June 12, 2023

**RE: Review Comment Responses / Space Village Filing No. 4
El Paso County, Colorado**

The purpose of this letter is to respond to the CDOT review comments dated 04/21/23 (1st Review). We have provided detailed responses to the review comments. We remain available to discuss further if needed. The following is a summary of comment responses:

SHEET TITLE: **SITE PLAN**

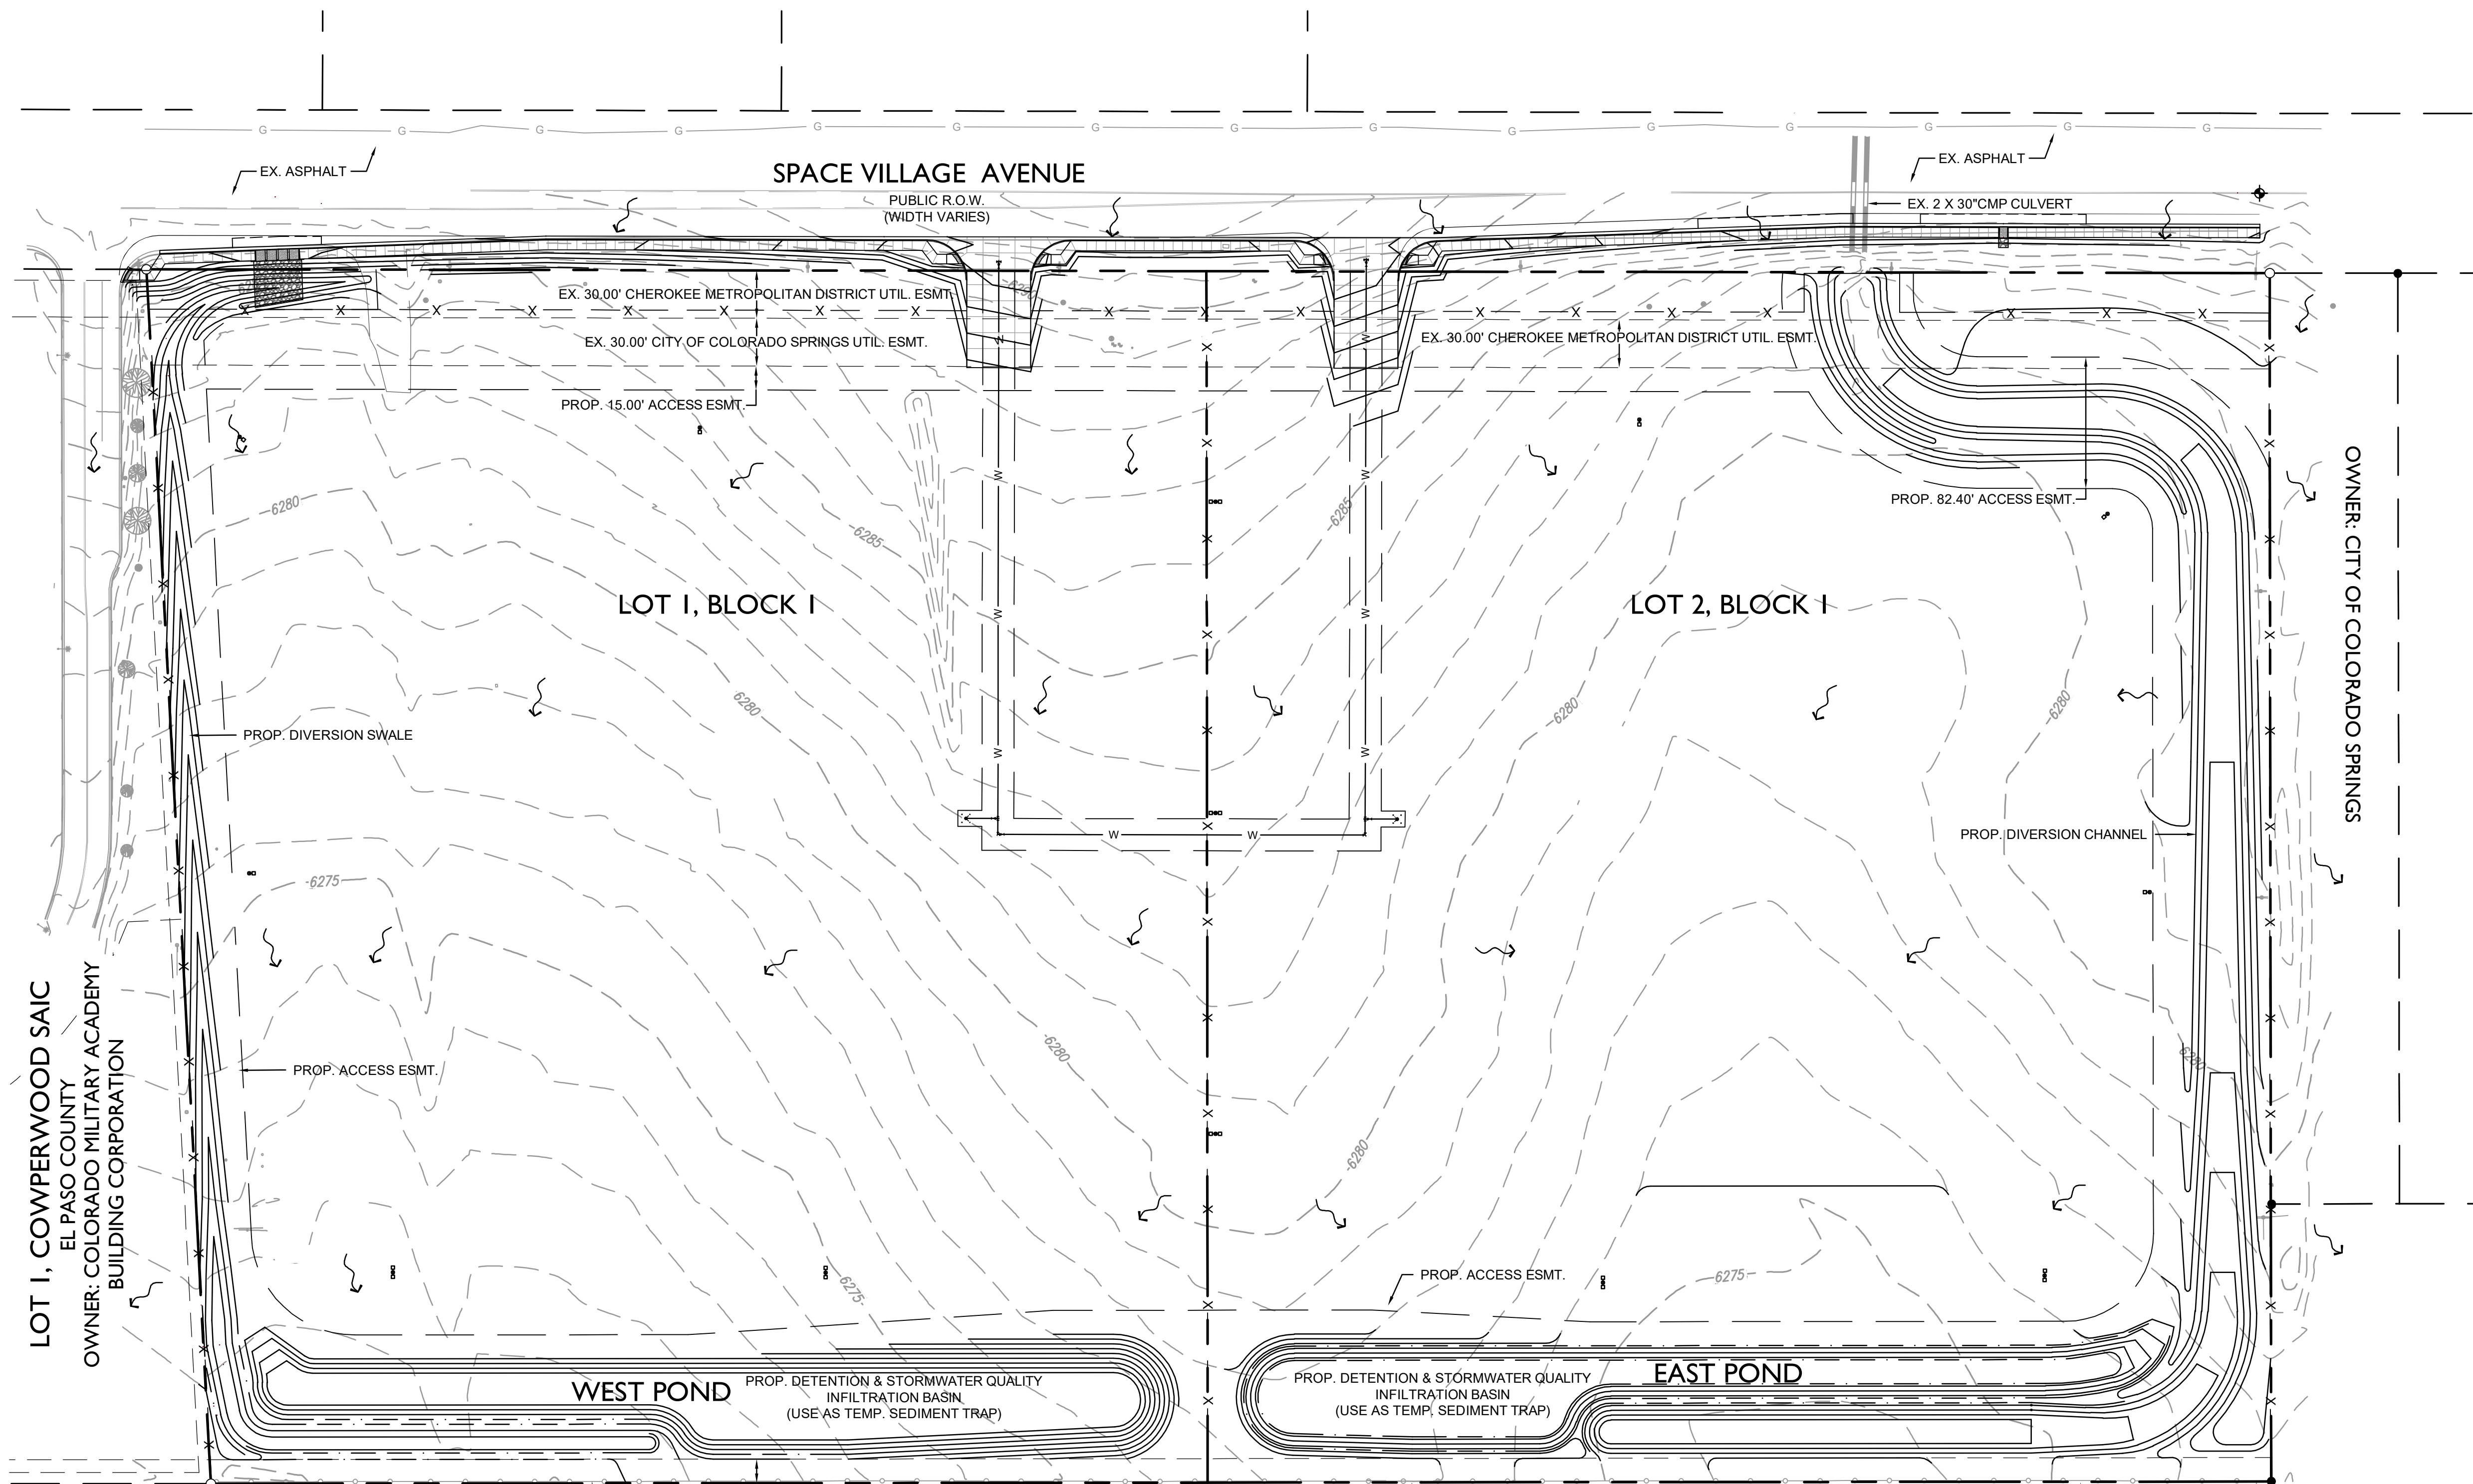
CDOT Comment 1: CDOT Traffic recommends that the proposed east access point line up with the access to Storage Sense that is on the northside of Space Village. This driveway placement would eliminate a potential overlapping left between the two driveways.

Comment Response: Comment acknowledged.
